# CHEROKEE METROPOLITAN DISTRICT

## LIFT STATION NO. 1 ADDITIONS

### SITE DEVELOPMENT PERMIT: PPR-2254

CHEROKEE METROPOLITAN DISTRICT
 LIFT STATION NO. 1B
 EL PASO COUNTY, COLORADO
 SITE DEVELOPMENT PLAN

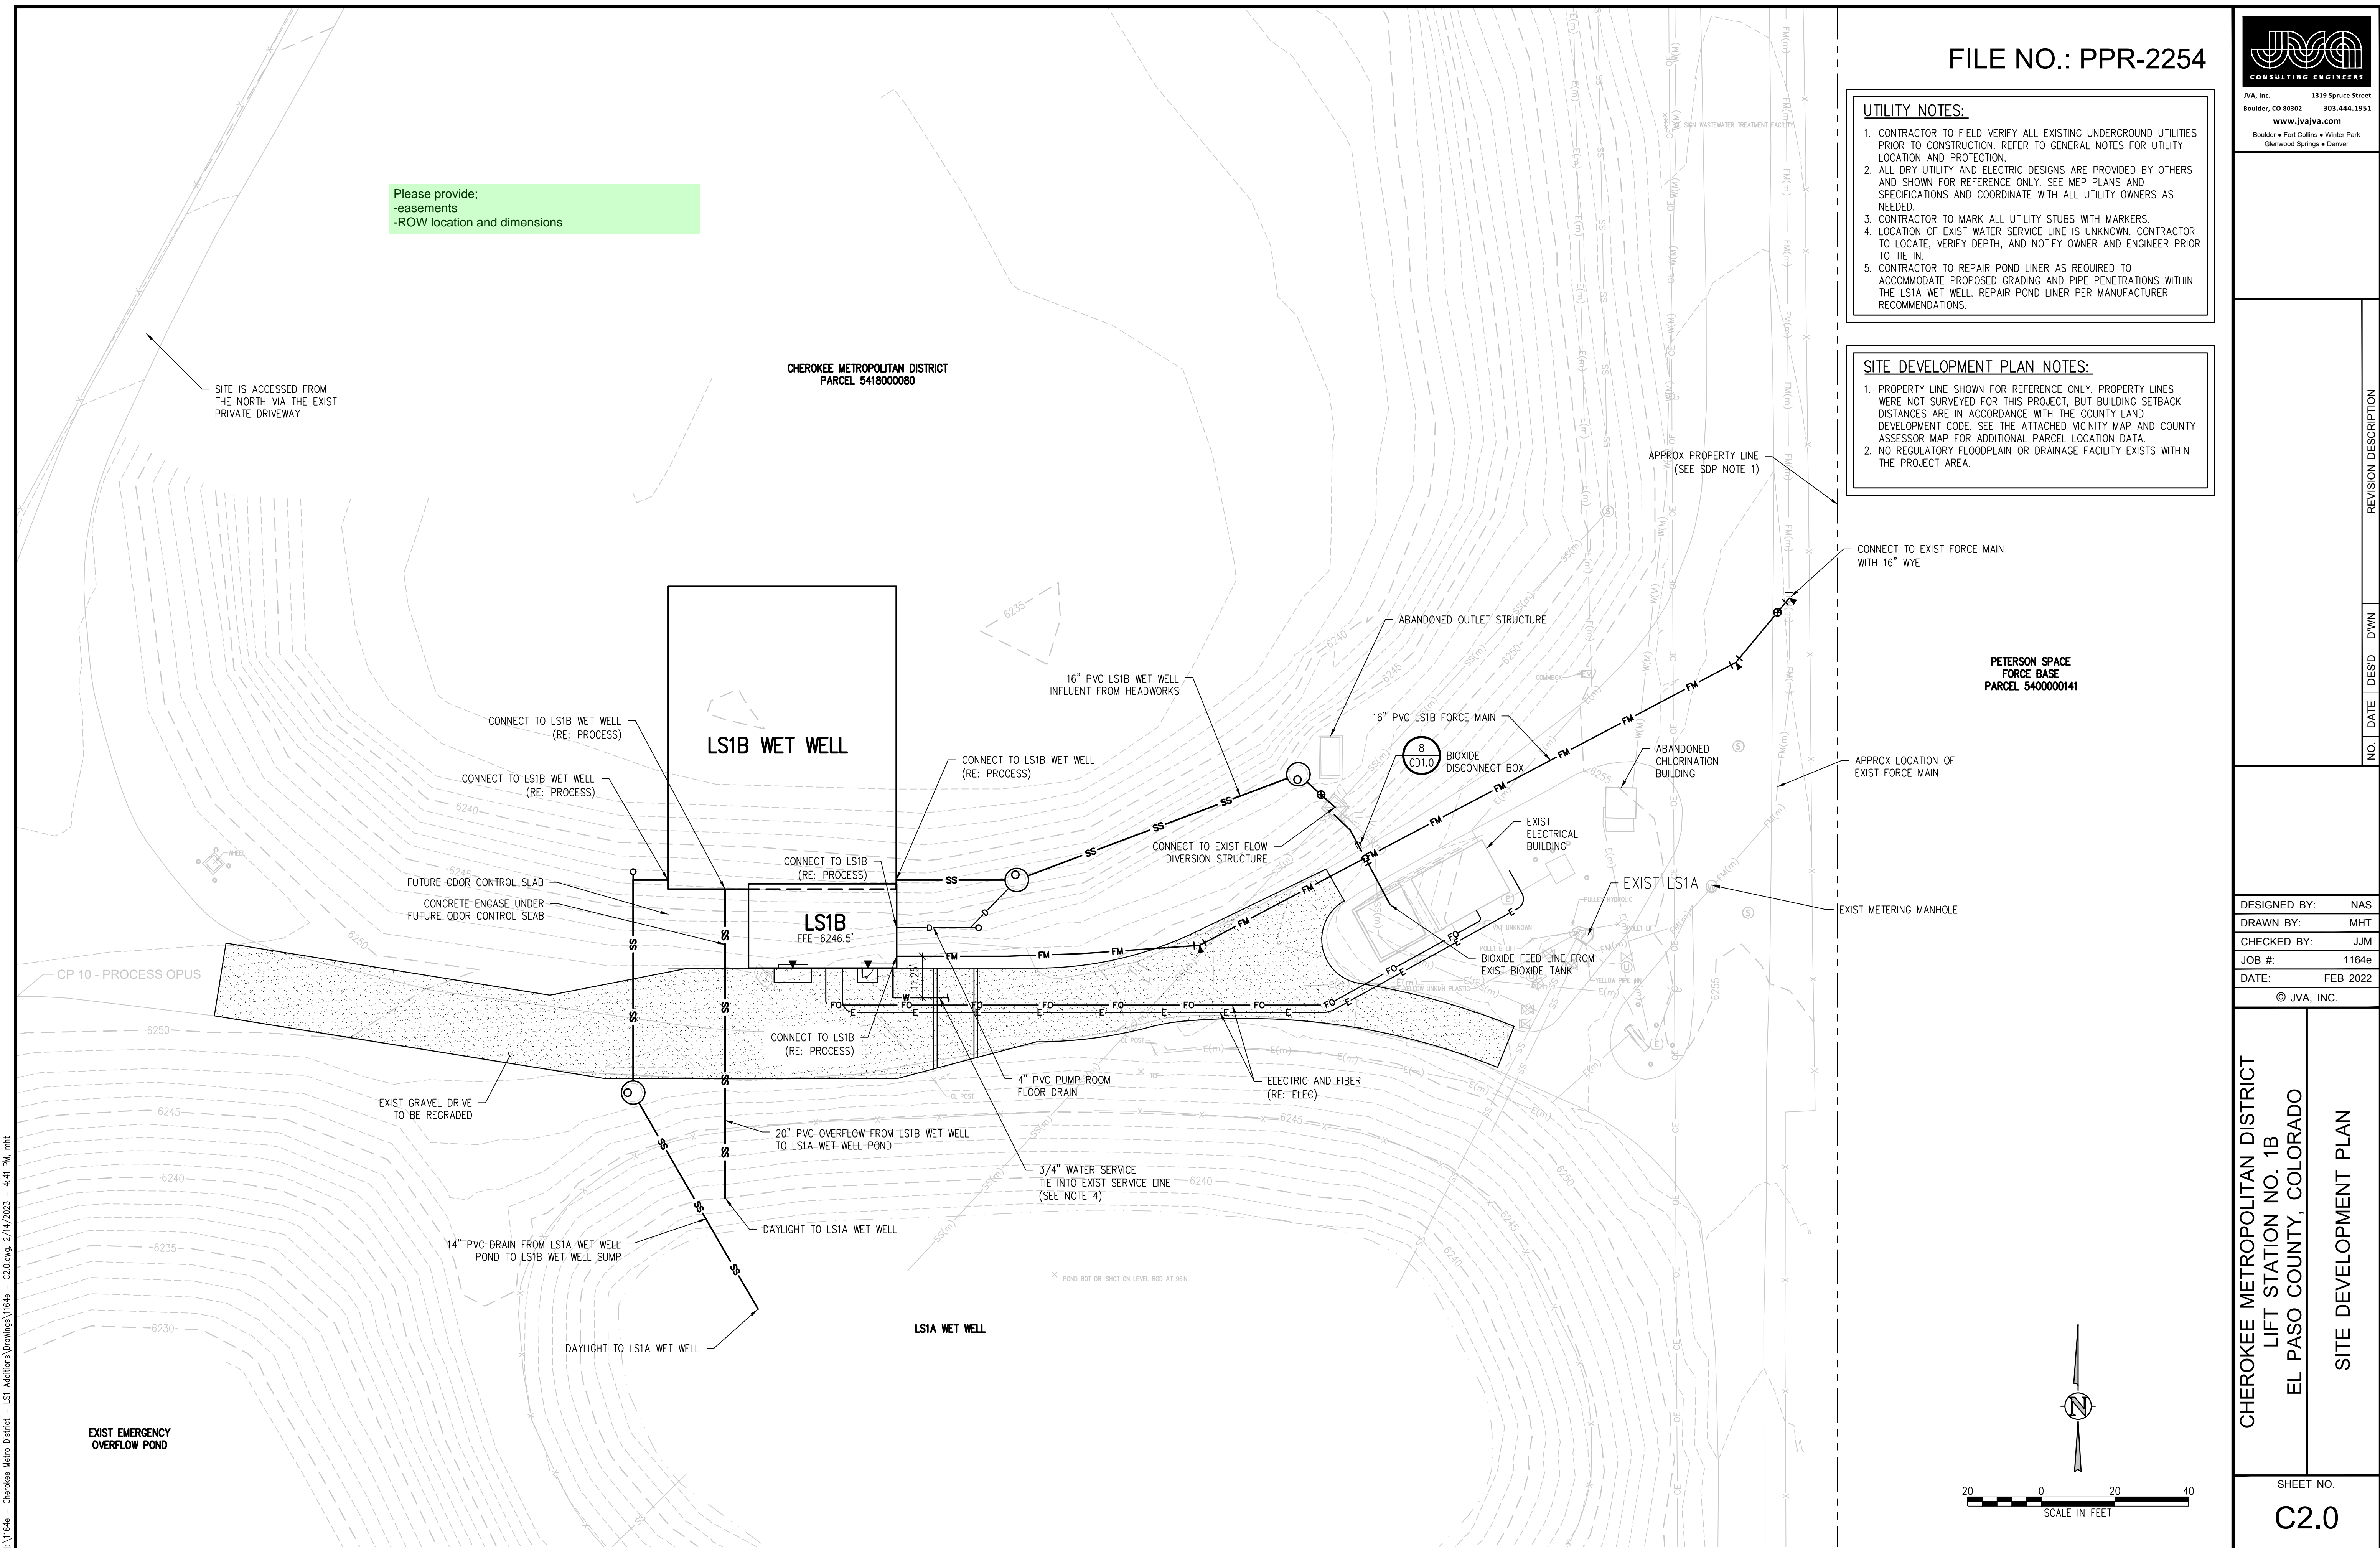
Please include:  
-parking computations, required vs provided

- Please include:
- location of garbage receptacles w/ screening mechanism
  - location of any utility lines

Recommend resizing and reorientation of SDP drawing to encapsulate entire property boundary. Should reflect floodplain area within the property and all existing structures, tanks and buildings within the property boundary. The CEC sheet(s) can focus on the project area and a bubble call out on the SDP can drill down into the project area. This SDP only shows a portion of the property i.e project area. An SDP needs to show the entire property.
